**SUPPLEMENTARY INFORMATION**

Site Name	Land at Tittenhurst Park	Site Address	Land southwest of Tittenhurst Park, London Road, Ascot, SL5 0PP
NGR	E: 494966 N: 168167		
Site Ref Number	95980	Site Type	Macro

**Surveyed by:** Neil Gates  
**Created by:** Ignatius Lo  
**Approved by:** Kieran Tarpey

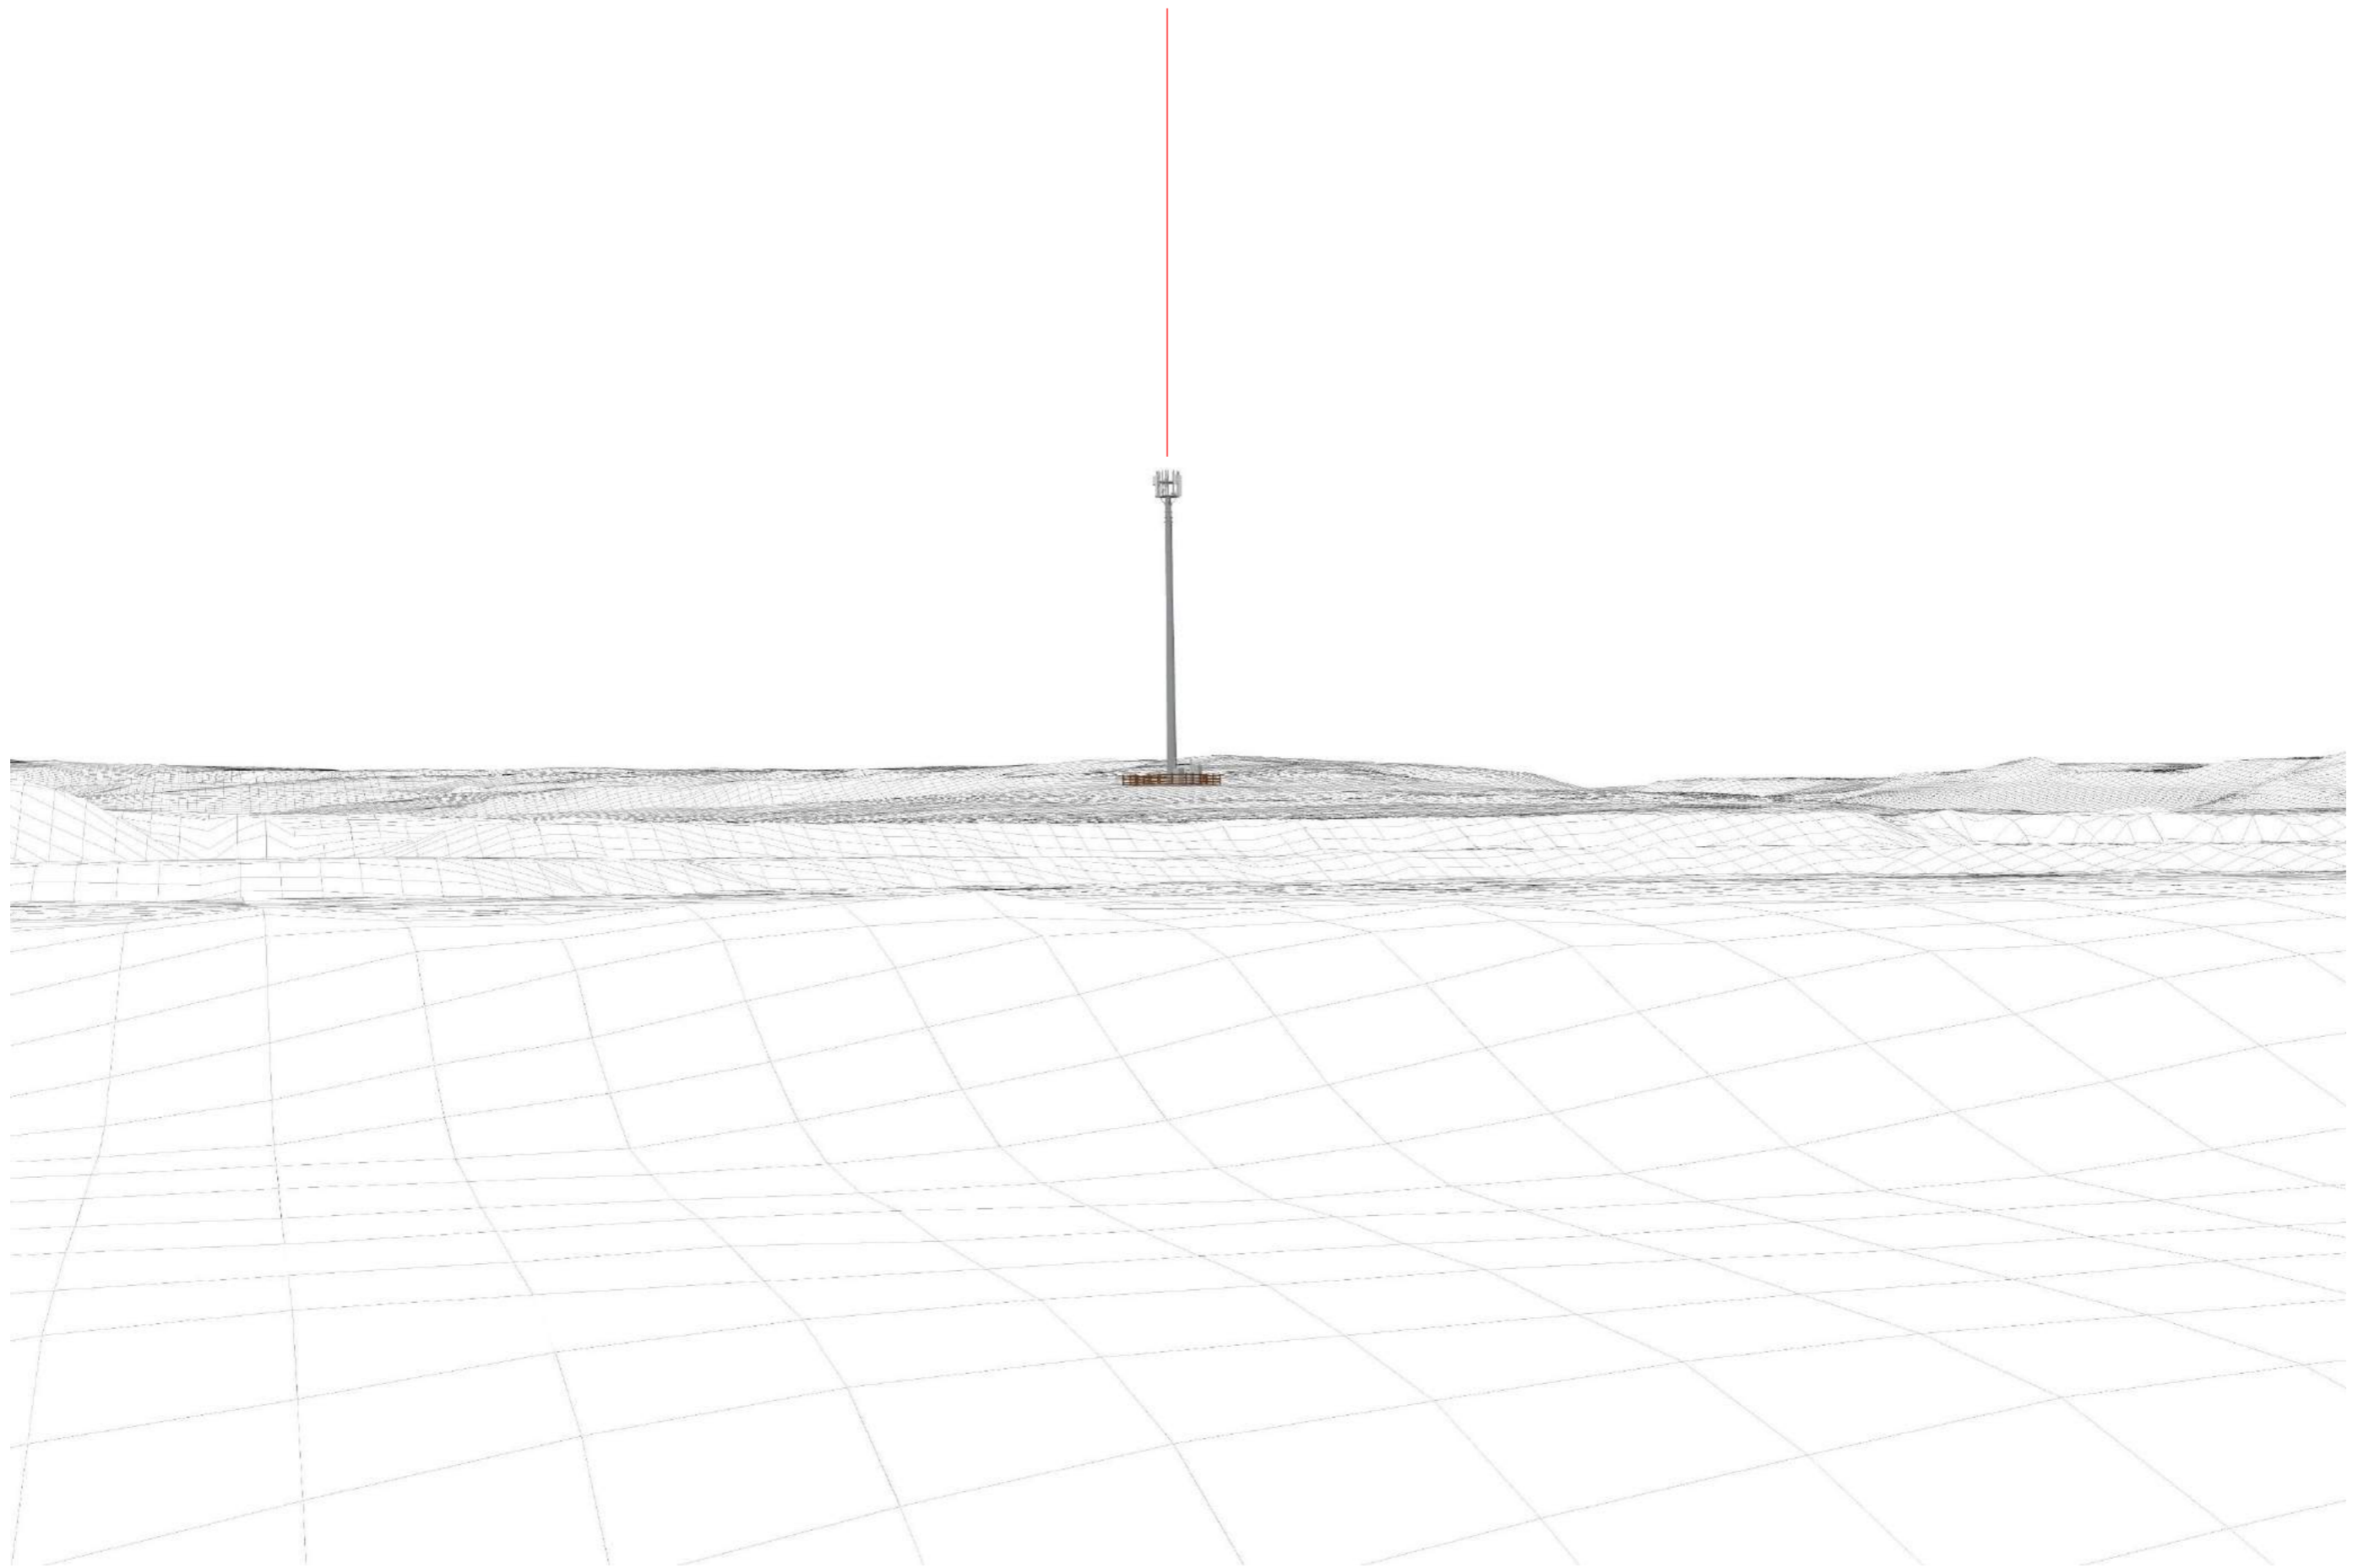
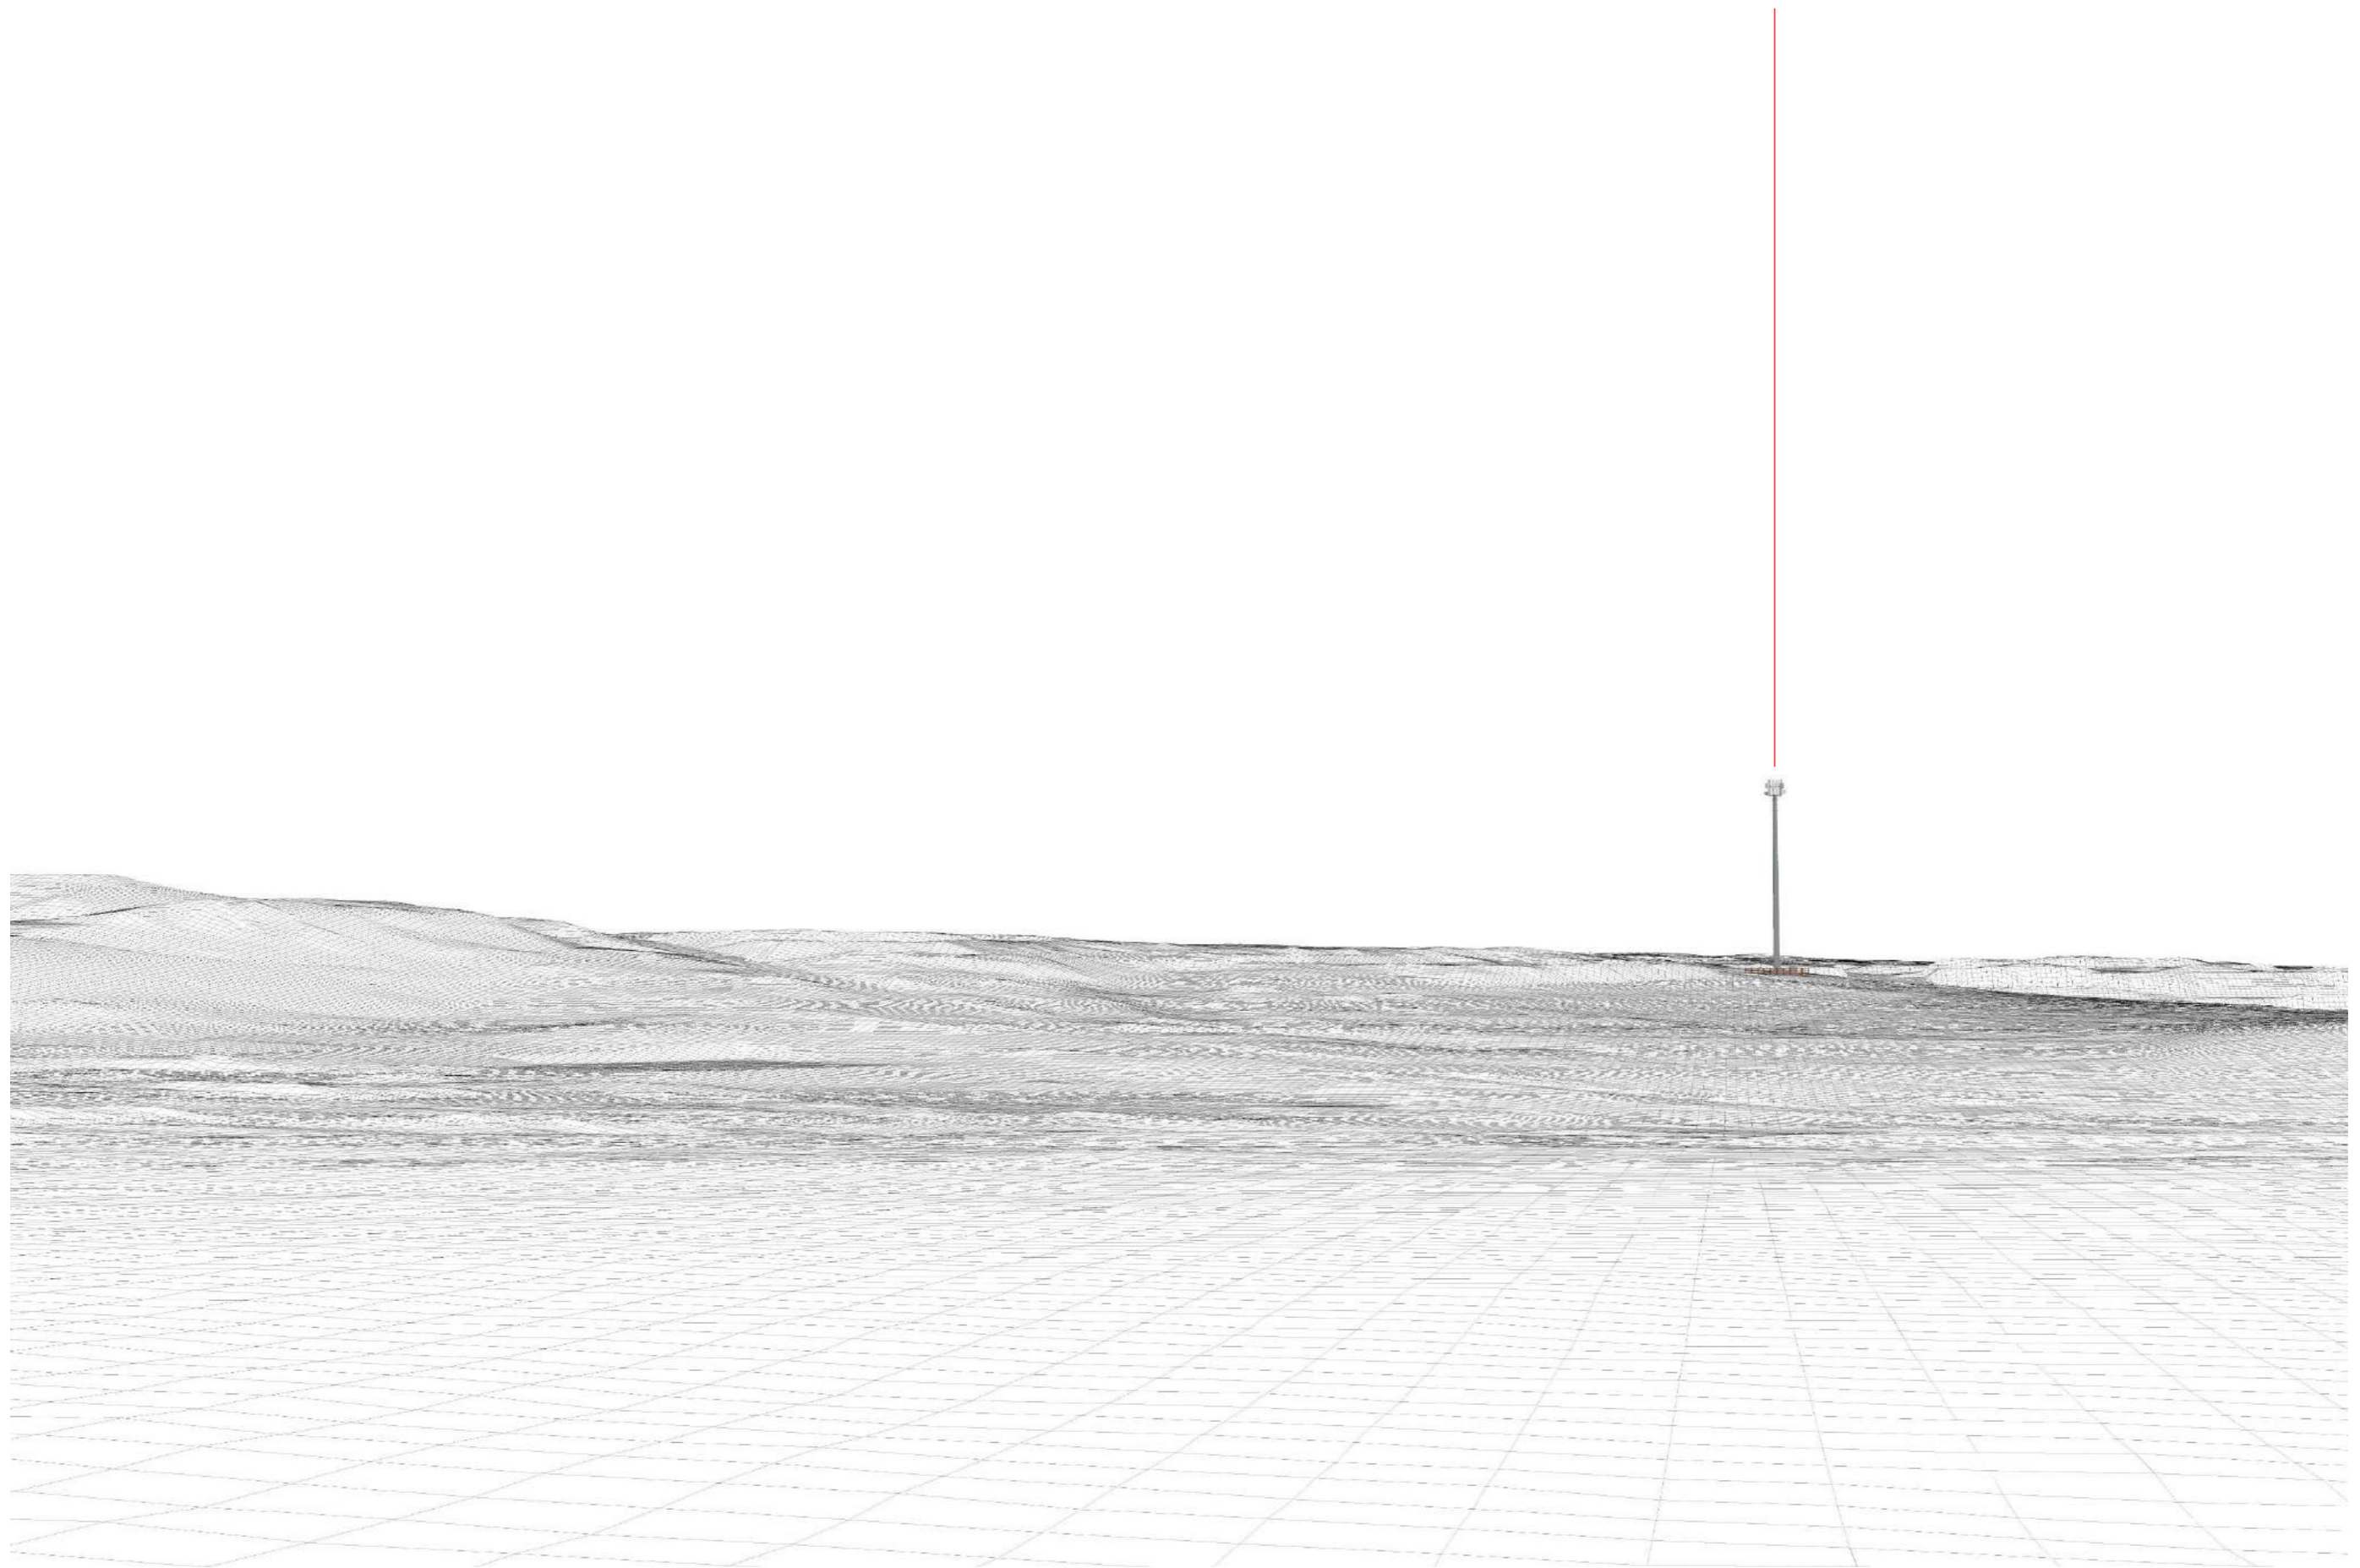
*“The impact on local character, landscape and heritage assets will be a key consideration. I note the intention to submit an LVIA but in the absence of that information we are unable to give any detailed advice on the likely acceptability of the scheme. There are some comments regarding the precedent set by the existing mast and the screening of the trees but given the proposed height of the mast I would not consider that the existing mast justifies this nor that surrounding trees would offer substantial screening. Based on information seen to date I would be concerned at the visual impact of the mast in this location.”*

Applicant Response – Given the site is located within a Greenbelt, a Photo Montage Report has been included from surrounding viewpoints. The existing mast sets the precedent that telecoms infrastructure is generally acceptable at this location in comparison to other sensitive locations in this area. Regarding the mature trees in this area, as can be seen from the Panoramic Survey Report enclosed in this application, the trees measure between 10m-30m which means there is sufficient screening for long range views when taking into account other natural vertical elements within the landscape. As demonstrated within the enclosed Photo Montage Report, visuals from public vantage points are mitigated as far as possible and the proposal is screened by trees from these viewpoints. Therefore, the visual impact from long range views is expected to be minimal on this area even given the height of 30m proposed.
